London Luton Airport Expansion

8.127 Applicant's Response to Deadline 5 Submissions

Appendix B - Buckinghamshire Council

Document Ref: TR020001/APP/8.127

Figure 4-1 Cycling catchment

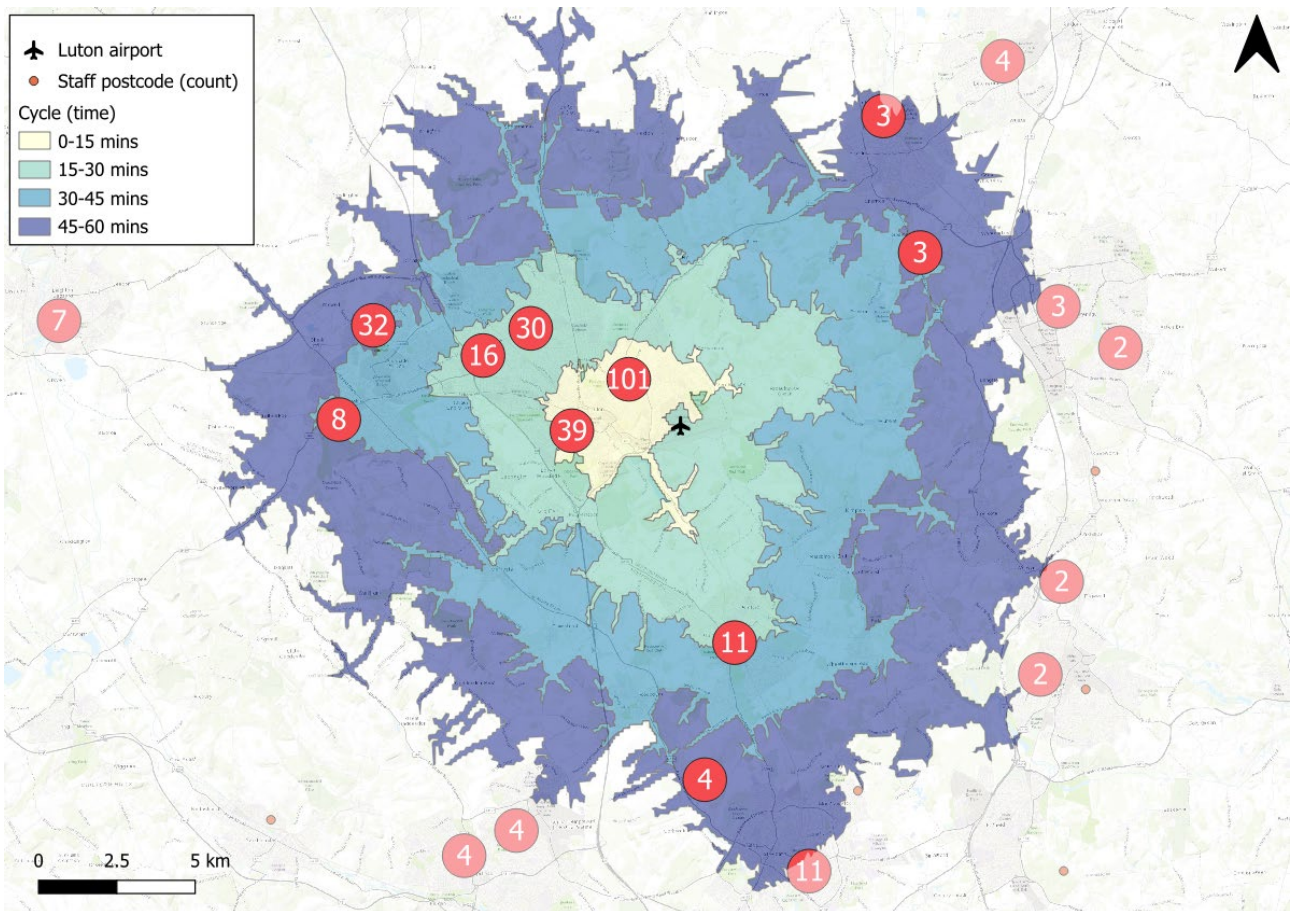
7	Surface Access	<p>REP4-084: 8.96 Applicant's response to Issue Specific Hearing 4: Action 29: Catchment area for staff walking and cycling</p> <p>It is noted that the outer most catchment of the cycling isochrones clip the edges of Buckinghamshire. It is questioned whether the Applicant has applied any correction factors for topography and available routes when producing these isochrones.</p> <p>The Council does not consider that there are any safe or suitable routes between the county boundary and the airport that could be considered appropriate for any significant numbers of people commuting between villages in the east of Buckinghamshire and the airport. In order to consider these isochrones to be representative of routes that people could be expected to use for sustainable access to the airport, an audit of available routes should have been carried out and areas where improvements are required identified to allow suitable corridors to be provided.</p>	<p>The street-based cycle isochrones account for speed changes due to the underlying elevation (speed will be lower for uphill journeys) and road type specific speed restrictions, with a standard speed on a flat road of 13mph.</p> <p>To undertake a full audit of all cycle routes was not considered necessary prior to examination. Exact routes were not considered at this stage, as the appropriate place to address this is in the future Travel Plans as part of the monitoring and mitigation process.</p>

Figure 5 – CBLTM-LTN Core Validation and Calibration screenlines

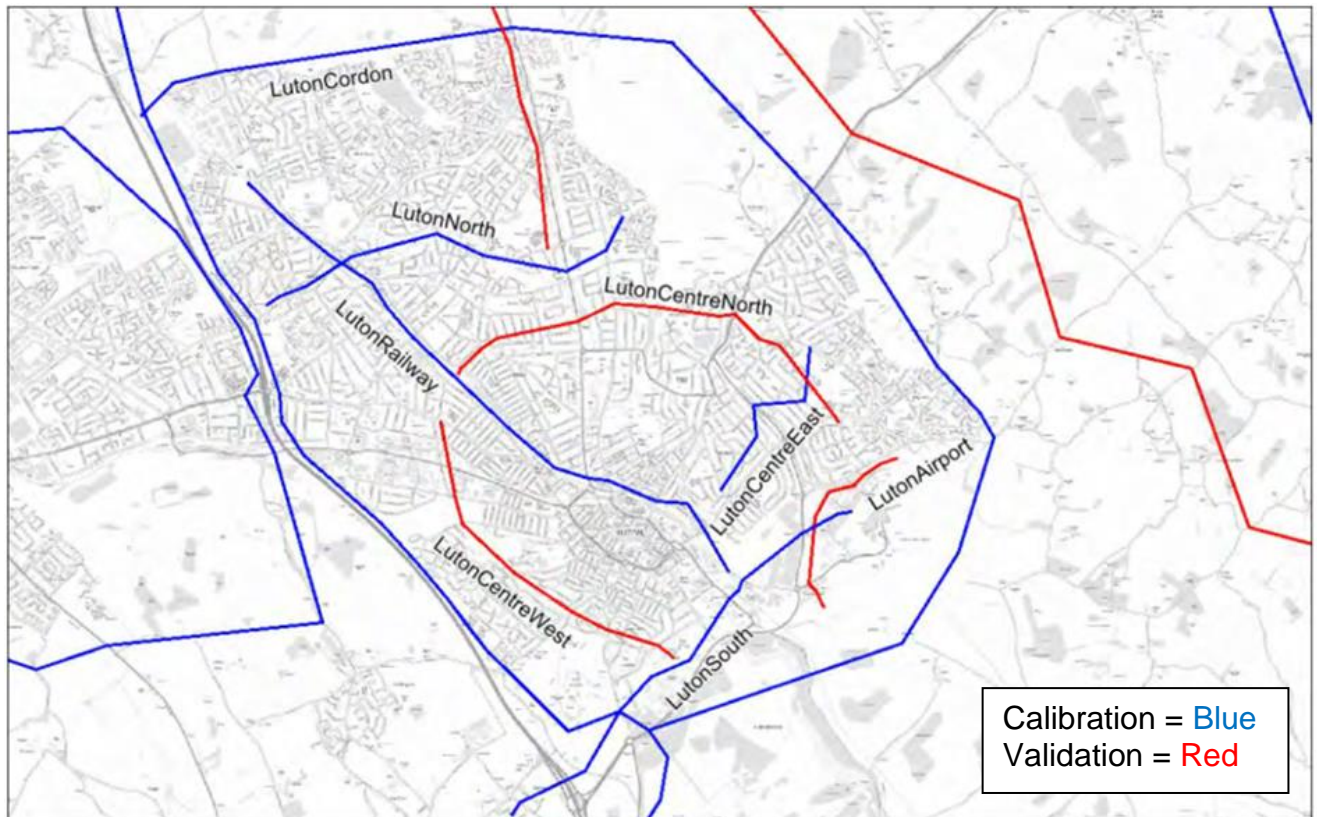
8	Surface Access	<p>REP4-085: 8.97 Outline Transport Related Impacts Monitoring and Mitigation Approach (TRIMMA)</p> <p>The Council considers paragraphs 2.1.2 and 2.1.3 to be misleading. They set out that the TRIMMA is to be governed by a subgroup of the ATF steering group, but it then goes on to give details of the steering group and not the sub group. It is the Council's position and understanding from discussion with the Applicants that the whole steering group should be the governing group.</p> <p>The Council is concerned that the Applicant is setting out that Highway Authorities should be responsible for the costs of undertaking monitoring on behalf of the Applicant to show that their development has given need for mitigation type 2. A local authority has no funds of its own and is reliant on taxpayers to carry out its</p>	<p>As shown in Table 2.1 the ATF's subgroup and the Steering Group which will govern the TRIMMA are the same body.</p> <p>The Applicant has assessed the impact of the Proposed Development and has proposed mitigation for identified impacts. The Residual Impacts Fund will exist to mitigate previously unforeseen impacts which have been demonstrated to have arisen due to the proposed development.</p>

I.D	Topic	Deadline 5 submission (Verbatim)	Luton Rising's Response
		<p>functions. It should be incumbent on the Applicant to assess and mitigate the impacts of its own development.</p> <p>It is not possible to provide the ExA a position on the acceptance of the RIF as this has not been presented to the Council at this time. It is however said to be finite, which will be acceptable on the basis that it is of a significant enough value to deliver a range of potential schemes and will not be exhausted too readily, and therefore nullifying the proposals of the mitigation type 2.</p> <p>The Council welcomes the examples of the RIF Indicative Principles, of a maximum allocation per year, and a maximum allocation per authority, as ways of ensuring that each authority has the ability to access funding if required.</p>	
9	Surface Access	<p>REP4-086: 8.98 Applicant's response to Issue Specific Hearing 4 Action 2: Covid 19 Additional Modelling Technical Note 1</p> <p>The Council acknowledges the national trends identified within the Technical Note and is conscious of the work undertaken within the host authorities' areas. It is noted that no assessment has been carried out within Buckinghamshire and so it is not possible for the Council to determine if these trends are replicated within it network. The Council's concern remains that the modelling has not been validated for the Buckinghamshire Network and so conclusions drawn from the strategic modelling work cannot, as yet, be considered robust in this area.</p> <p>As part of the Deadline 3 submission, the Council offered to provide recent survey data to be used as part of a 2023 baseline or requested that the Applicant carry out their own surveys of this route. However, this request has not been included as part of the recent submissions. This offer to the Applicant remains.</p>	<p>The Applicant considers the strategic transport model is a suitable tool to assess the level of traffic impact on the highway network in Buckinghamshire for the following reasons:</p> <ol style="list-style-type: none"> 1. The model has been calibrated and validated as per the DfT's TAG guidance and considered fit for purpose by all Host Authorities and National Highways. 2. The model includes Buckinghamshire within its modelled simulation, with the fully modelled area covering much of the county. This is shown in 7.02 Transport Assessment Appendices - Part 1 of 3 Appendix E1: Highway LMVR (LMVR) [APP-201], Figure 4.1 CBLTM-LTN Fully Modelled Area and in the LMVR Figure 7.1 Luton Airport and Non-Airport CBLTM-LTN Zones. 3. The mobile phone demand data, upon which the model travel demands have been built, includes the whole of Buckinghamshire, as shown in the LMVR [APP-201] Figure 5.7 CBLTM-LTN Mobile Network Cordon. 4. The model has also been calibrated / validated to screenlines for demands to/from the county, as shown in LMVR [APP-201] Figure 11.2 'Initial Assignment Calibration' Screenline Classification (Calibration=blue Validation=Red) – Overview. <p>The CBLTM-LTN is a strategic model covering a large area and the focus on calibration and validation is concentrated around the scheme, and its area of impact. Therefore, the CBLTM-LTN core calibration and validation area covers the area surrounding London Luton Airport as reported in Figure 11.3 of the LMVR [APP-201], which is replicated below.</p>

Figure 15 – B489 Daily Traffic (east of the Junction with B488) – 18 vs 32 mppa

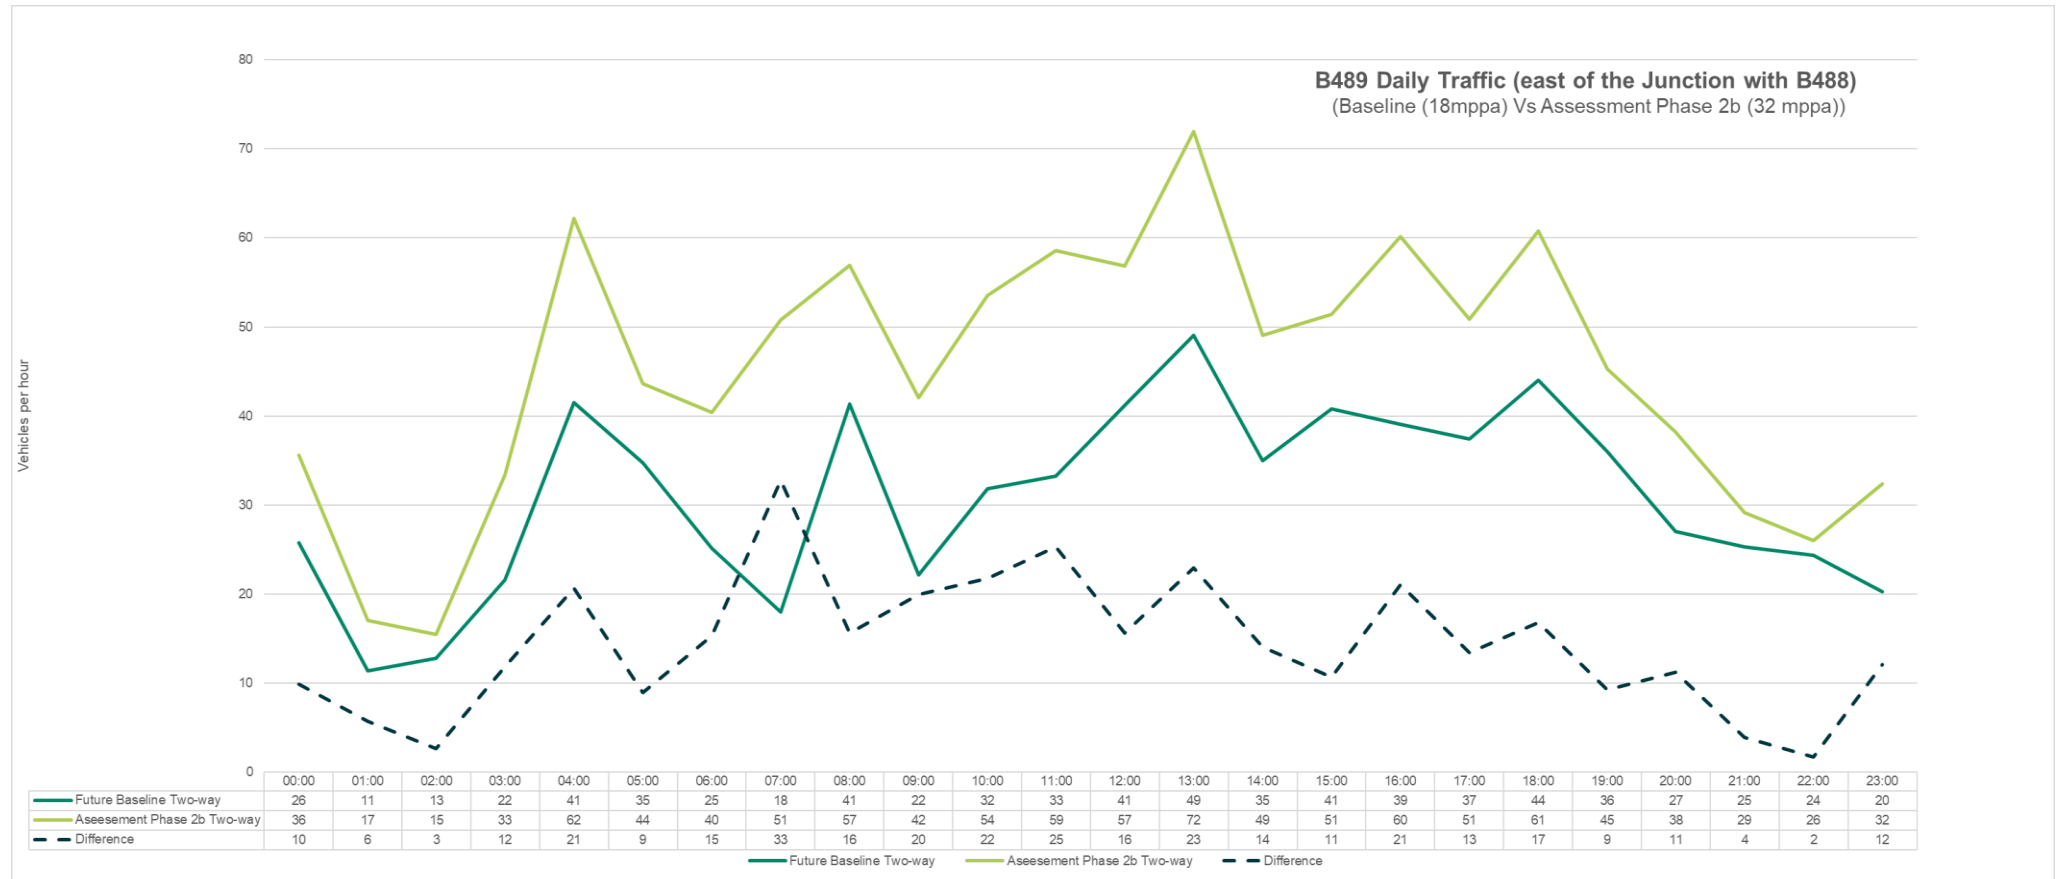
I.D	Topic	Deadline 5 submission (Verbatim)	Luton Rising's Response																																																																																																																													
10	Surface Access	<p>REP4-087: 8.99 Applicant's response to Issue Specific Hearing 4: Action 6 Traffic on B489 Link</p> <p>This note only details the forecasted traffic flow differences for the network peak hours and does not provide flow differences across a 24-hour period. Further information is therefore requested to allow a final judgement to be made on the full impact on this route and any necessary mitigation measures that may be required.</p> <p>Furthermore, both the submitted Transport Assessment and the Traffic on B489 Link document do not contain information on the baseline survey data used as part of the strategic modelling. The model used to inform the forecasted traffic growth is not validated within Buckinghamshire and the Council is therefore unaware of the survey data used to inform this. As part of the Deadline 3 submission, the Council offered to provide recent survey data to be used as part of a 2023 baseline or requested that the Applicant carry out their own surveys of this route. However, this request has not been included as part of the recent submissions. The Council can therefore not be confident that the modelling provided is reliable and further work is required.</p>	<p>the county) are considered 'fit for purpose'. Moreover, the relatively low demands to and from Buckinghamshire, as has been reported in the Trip Distribution Plans, also support this position. However, if the data is provided the Applicant is willing to undertake a comparison.</p> <p>The Applicant has extracted the daily airport traffic, from the reported Trip Distribution Plans, travelling along the B489, and then profiled the traffic over 24-hours utilising the airport passengers trip generation profile. The results are shown in the figure below.</p> <p>The figure shows that the highest hourly increase in airport traffic along the B489 is less than 20 vehicles per hour at each direction, and less than 30 vehicles per hour two-way.</p>

<table><tr> <th></th> <th>00:00</th> <th>01:00</th> <th>02:00</th> <th>03:00</th> <th>04:00</th> <th>05:00</th> <th>06:00</th> <th>07:00</th> <th>08:00</th> <th>09:00</th> <th>10:00</th> <th>11:00</th> <th>12:00</th> <th>13:00</th> <th>14:00</th> <th>15:00</th> <th>16:00</th> <th>17:00</th> <th>18:00</th> <th>19:00</th> <th>20:00</th> <th>21:00</th> <th>22:00</th> <th>23:00</th> </tr><tr> <td>Total = 404</td> <td>13</td> <td>5</td> <td>8</td> <td>14</td> <td>26</td> <td>22</td> <td>16</td> <td>10</td> <td>21</td> <td>11</td> <td>19</td> <td>19</td> <td>23</td> <td>26</td> <td>18</td> <td>23</td> <td>22</td> <td>21</td> <td>23</td> <td>18</td> <td>13</td> <td>12</td> <td>11</td> <td>9</td> </tr><tr> <td>Total = 578</td> <td>17</td> <td>8</td> <td>7</td> <td>20</td> <td>37</td> <td>27</td> <td>25</td> <td>27</td> <td>29</td> <td>22</td> <td>30</td> <td>33</td> <td>31</td> <td>37</td> <td>25</td> <td>29</td> <td>33</td> <td>28</td> <td>32</td> <td>23</td> <td>19</td> <td>14</td> <td>12</td> <td>14</td> </tr><tr> <td>Total = 335</td> <td>13</td> <td>6</td> <td>7</td> <td>8</td> <td>16</td> <td>13</td> <td>9</td> <td>8</td> <td>20</td> <td>11</td> <td>13</td> <td>14</td> <td>18</td> <td>23</td> <td>17</td> <td>17</td> <td>17</td> <td>16</td> <td>21</td> <td>18</td> <td>14</td> <td>13</td> <td>13</td> <td>11</td> </tr><tr> <td>Total = 504</td> <td>18</td> <td>9</td> <td>8</td> <td>13</td> <td>25</td> <td>17</td> <td>16</td> <td>24</td> <td>28</td> <td>20</td> <td>23</td> <td>26</td> <td>26</td> <td>35</td> <td>24</td> <td>23</td> <td>28</td> <td>23</td> <td>29</td> <td>23</td> <td>20</td> <td>15</td> <td>14</td> <td>18</td> </tr></table>
